Boys + Girls Club

RE: Sagamore Boys and Girls Club-27 Popham Street

CBL: 274 H001  
Application: #09-79900002

June 2, 2009

sheet number
S1.1

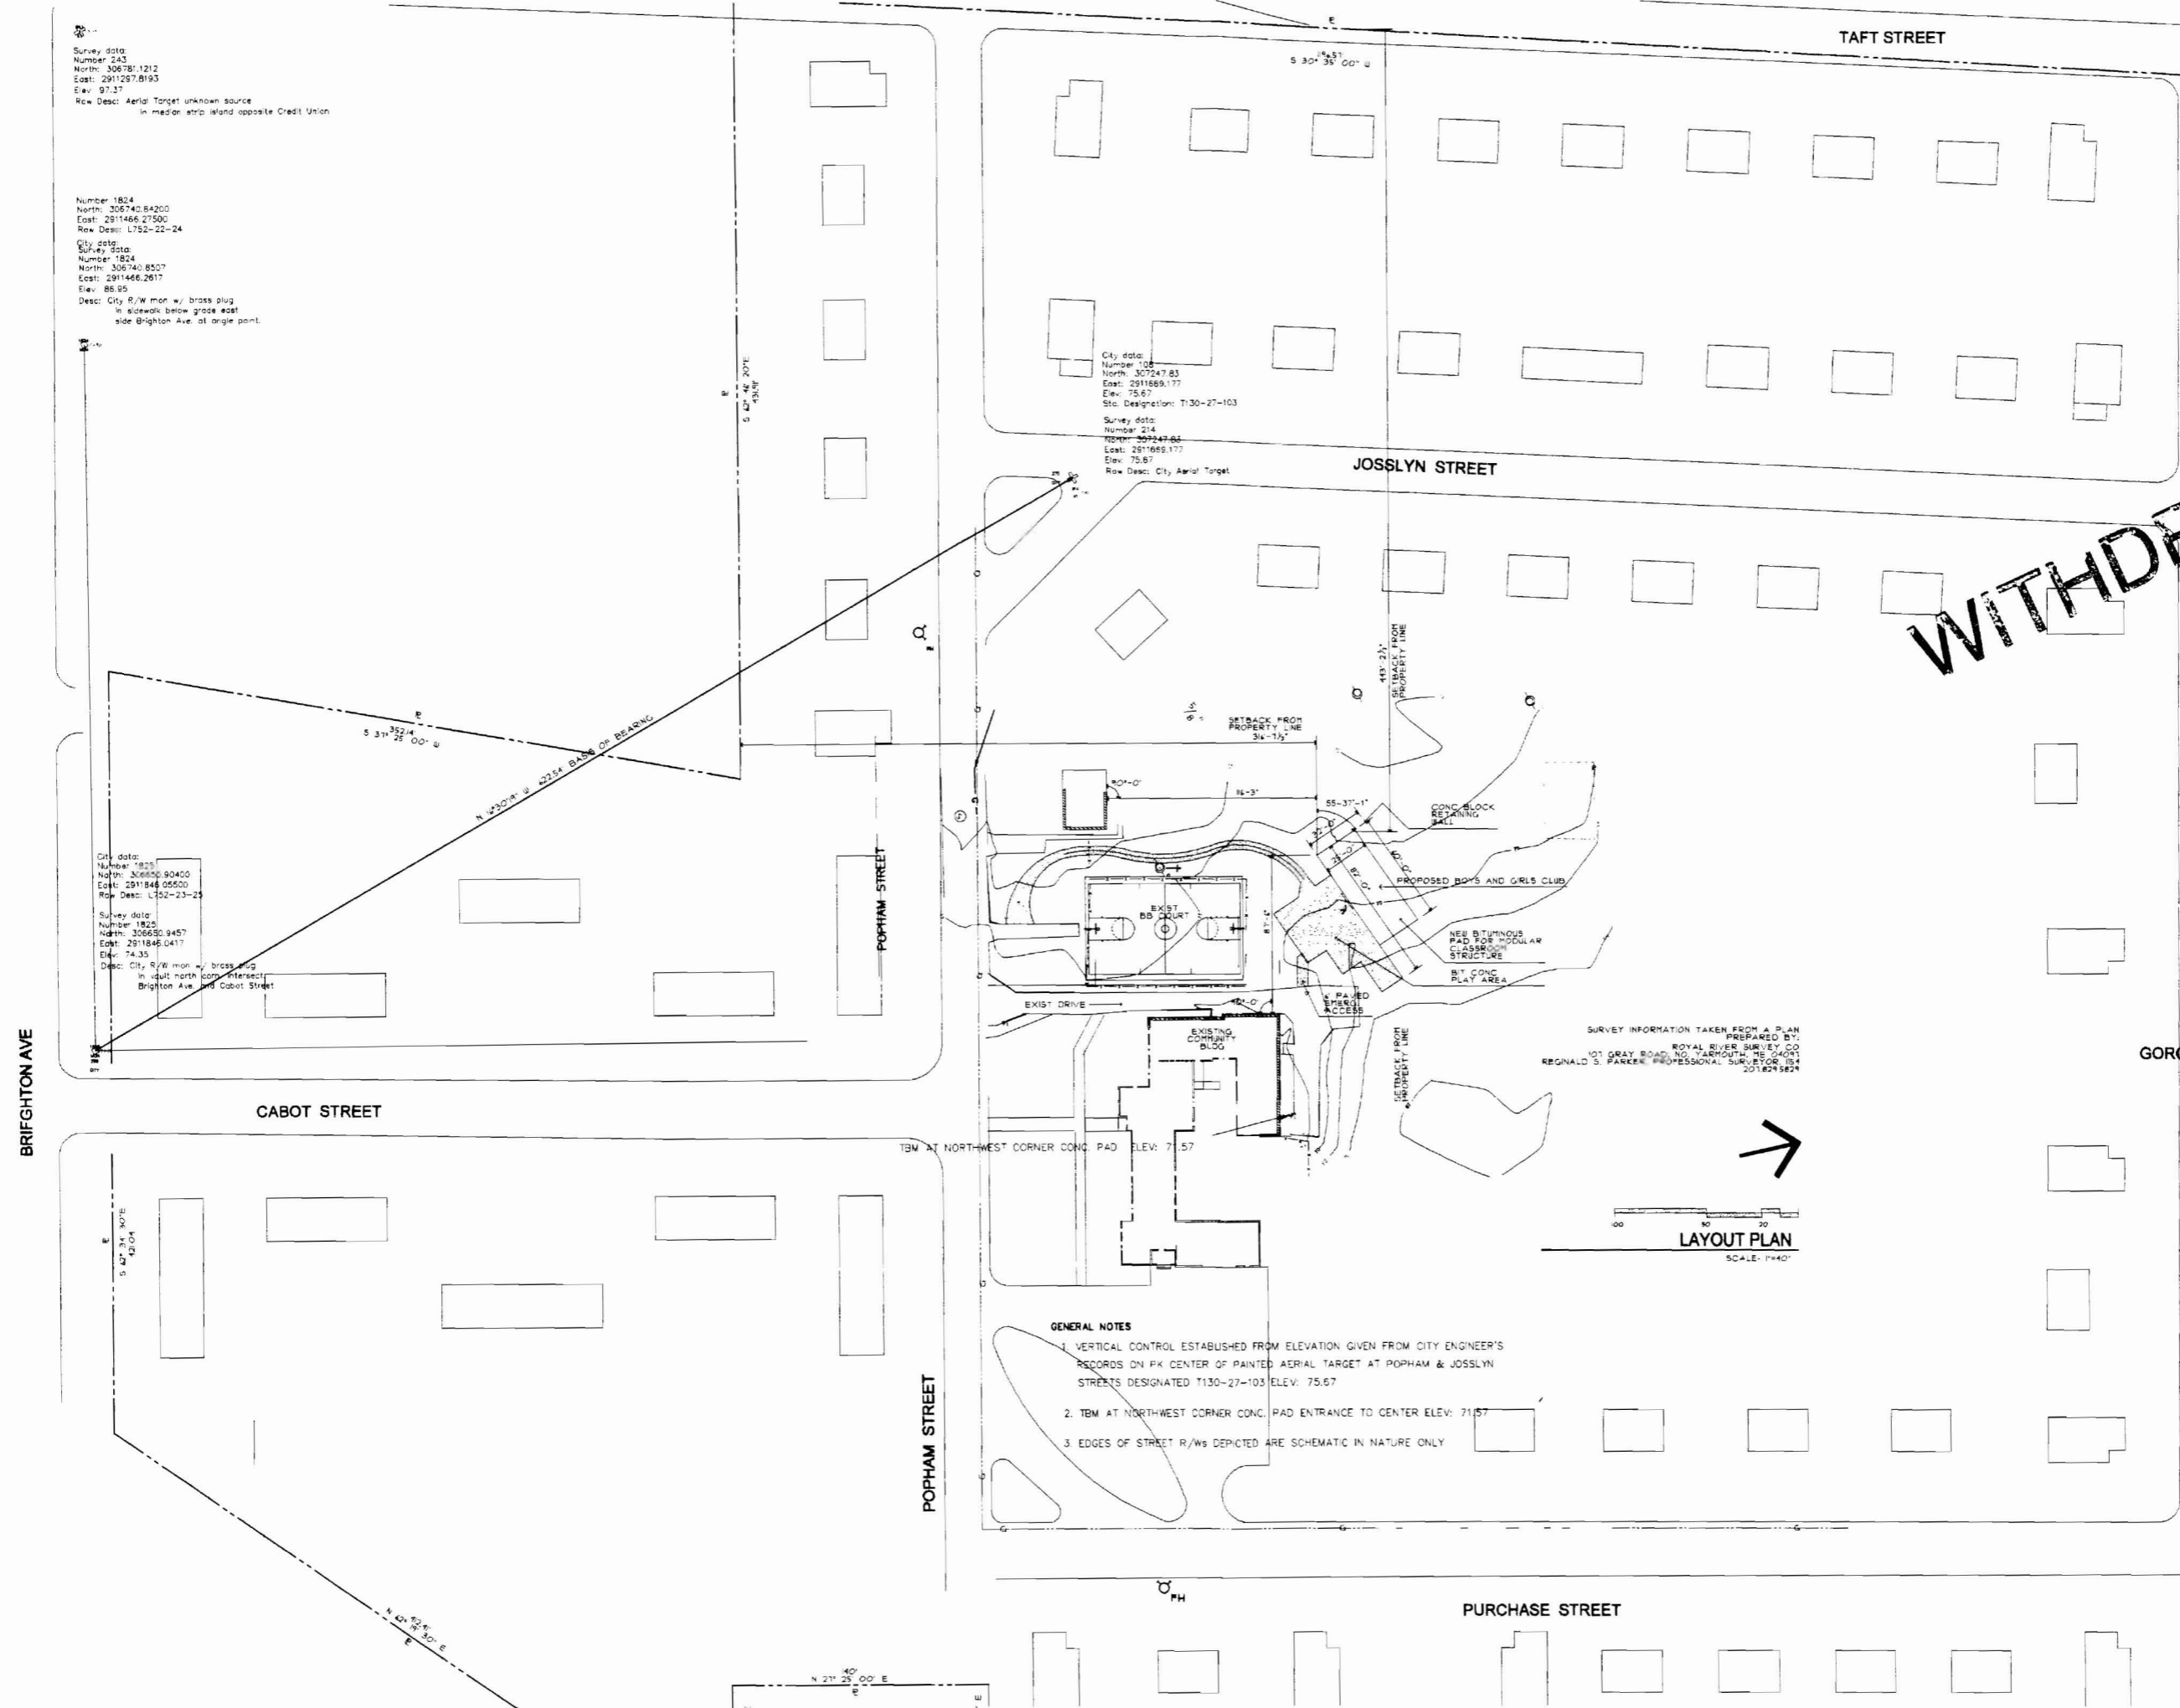
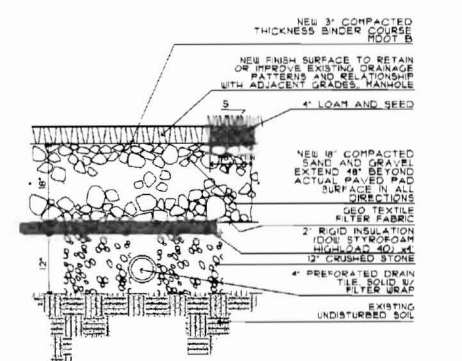
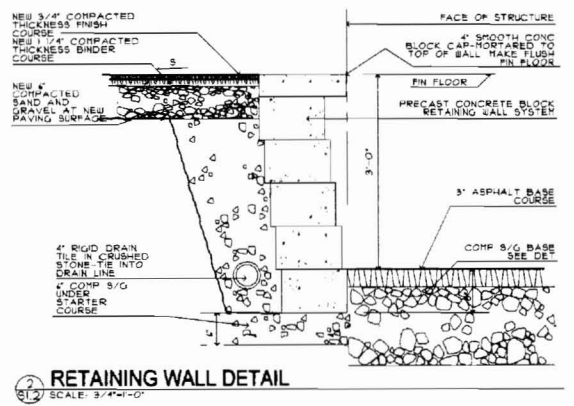
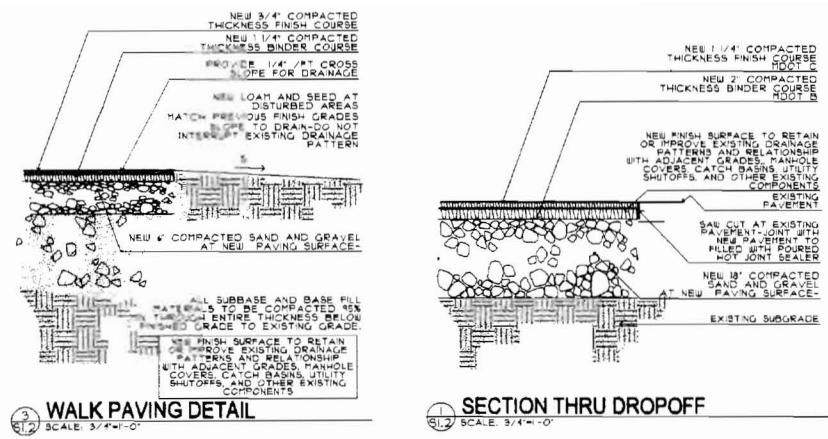
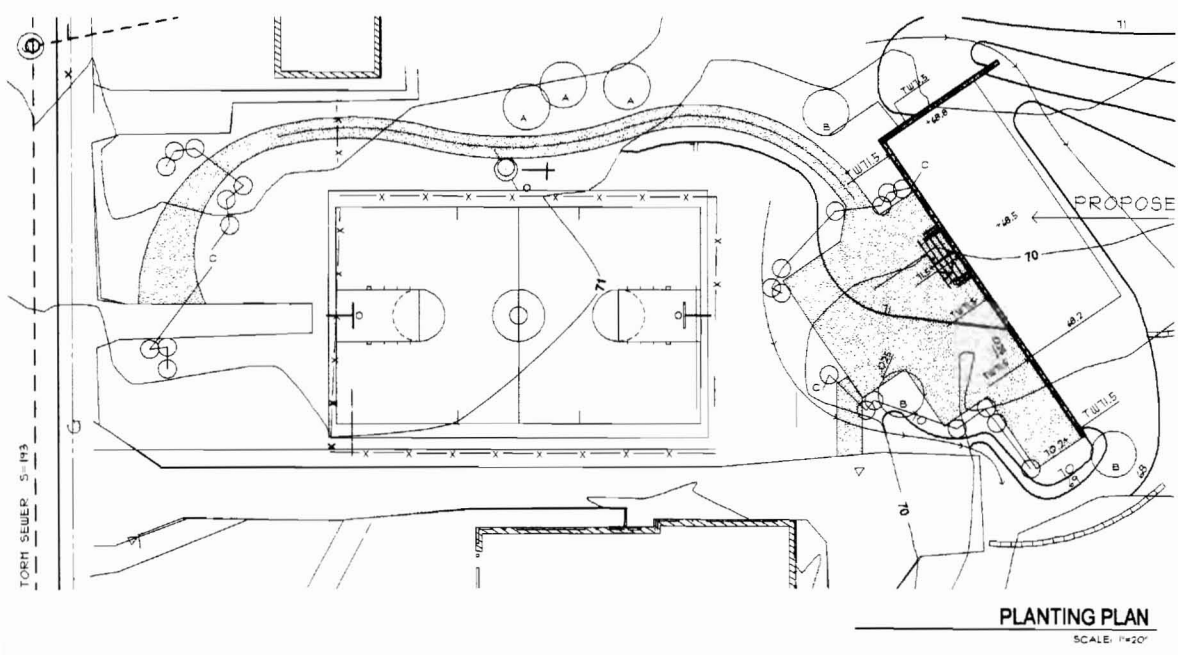
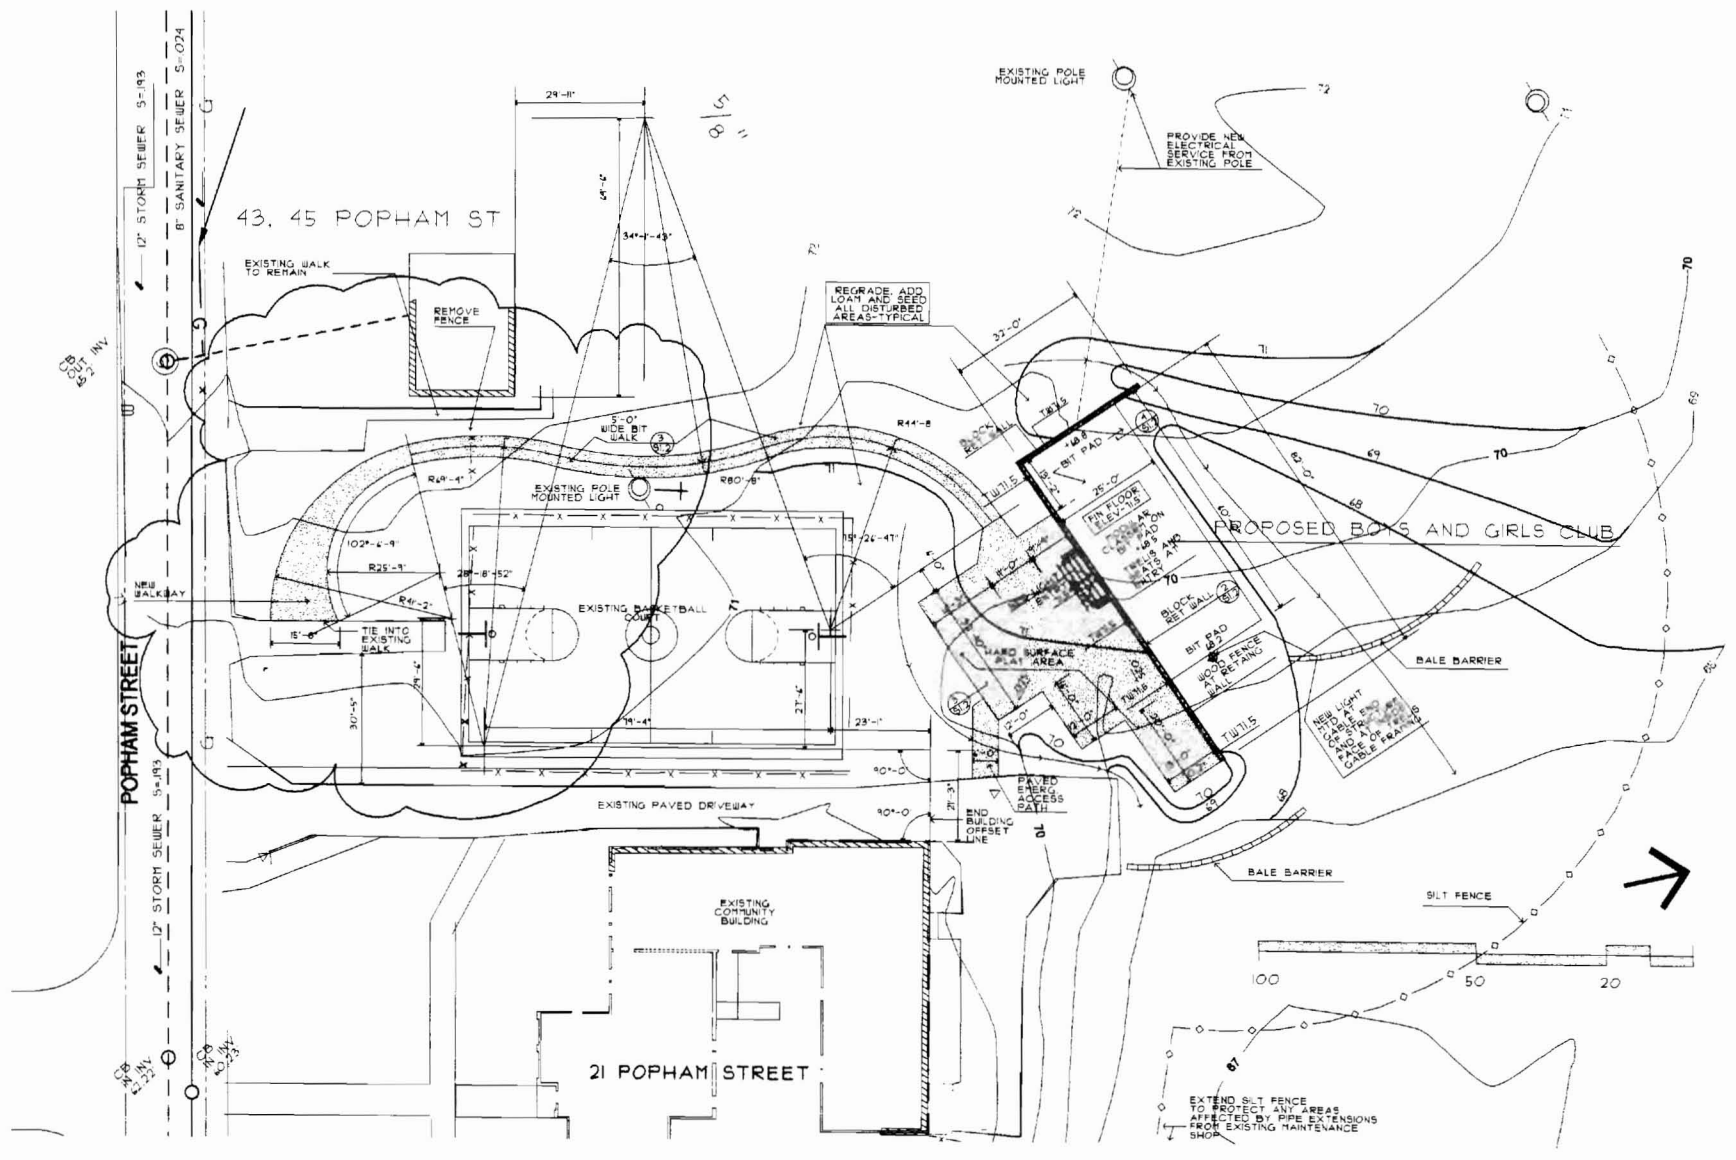
- There are two new lighting is being proposed as part of this project, are these the same fixtures as each other. It seems like the one on the northeast corner is a ole fixture and the one on the building is a wall mount. Please explain as to what is actually being proposed; include the height and photometric for each light.
- Where is the closest residential unit to the lighting fixture on the northeast side of the building? The proposed lighting shall be invasive to surrounding residential units.
- The needs to be note on the site plan stating the 'existing drive to be relocated and removed'
- How many parking spaces are there in the existing parking lot; how many of these are used for the existing community center.
- Submit utilities capacity letters.
- Will the electrical service from the existing pole mounted light be under ground?

structures. Two parking spaces are being met for the new building as required. The application stated that three parking spaces are being provided, but the site plan does not show where the third parking space was located.

- The new driveway proposed for 43/45 Popham Street will not meet city standards for driveway separation. Based upon the low volume and travel speeds on Popham Street, I support a waiver from the standard.
- The existing driveway should be removed.
- I'm not sure a drop-off lane is necessary for this street given the level of traffic volume. I would also note that the separation between the existing driveway to the site and the drop-off does not meet separation standards for a local road, although this condition is somewhat unique. I would support a waiver for this.
- The width of the proposed driveway meets City standards.

The parking space WEST of the proposed drop off that is labeled as "relocated parking" serves the existing unit at 43, Popham Street. It will be moved up to make room for the drop off. It will not be used to serve the Boys and Girls Club.

The two spaces required for the Boys and Girls Club will be in the large parking area EAST of the Maintenance Building. Please refer to \*Sheet S1.1\*. The parking lot is located under the "General Notes" paragraph at the corner of Popham and Purchase Streets.

SITE PLAN
 SCALE 1"=30'

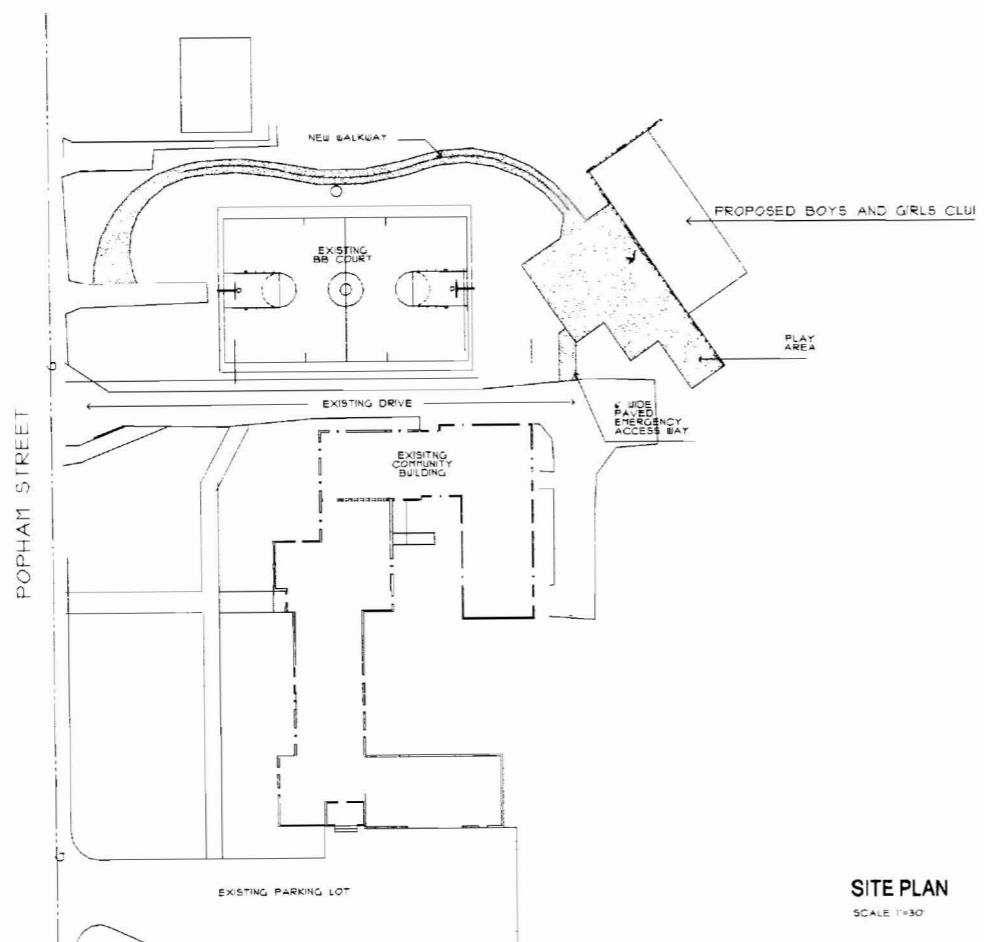
1. The final site plan shall depict a walkway from the existing driveway to the proposed building, as recommended by Captain Keith Gaudreau in his memo dated 06.18.2009.
